**Case Officer:** Catherine Harker      **Recommendation:** Approve

**Applicant:** Sir Stephen Gomersall

**Proposal:** Relocation of staircase, minor internal alterations associated with staircase and alterations to a single window and external door

Approximate Phasing Plan
The approximate phasing plan for the building with phases relating to:

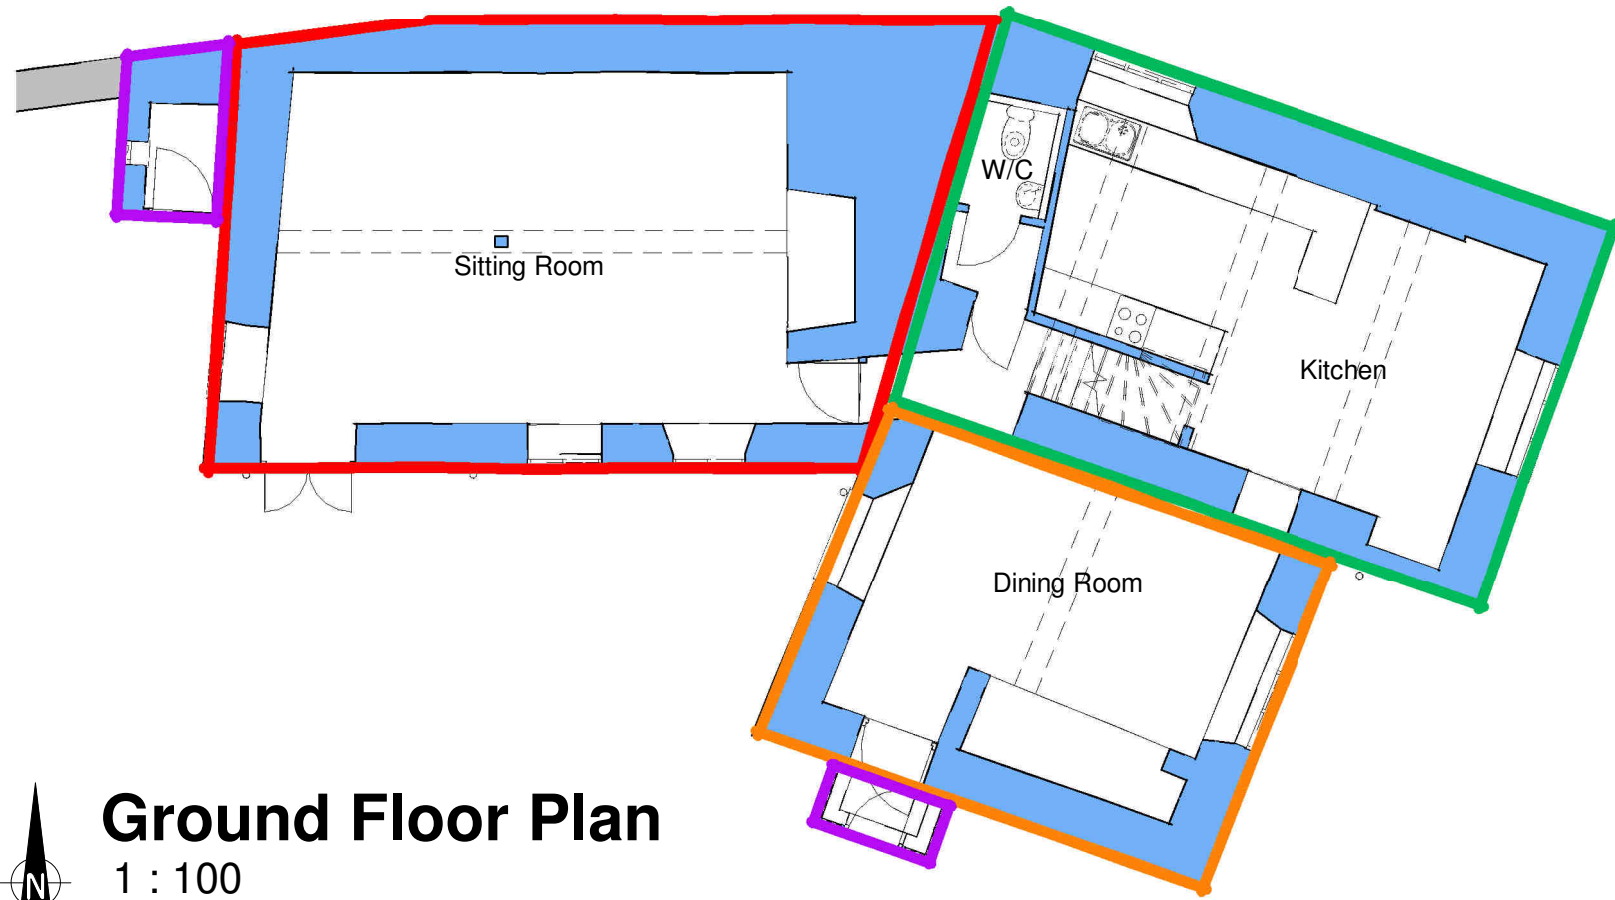
The Heritage Report accompanying the new application suggests the following phasing

- The single storey range to the west with the large chimney stack and deeply chamfered principal joist is the first phase 17th century;
- The two-storey range with attic range is the second phase, possibly replacing a previous range late 17th or early 18th century;
- The range to the south is the third phase early 19th century;

In relation to this suggested phasing is noted that the plan form of the eastern wing is not a true oblong, which it is highly likely it would have been, if built as a free-standing house. It runs off slightly obliquely from the western range. Also it does not have a principal fireplace.
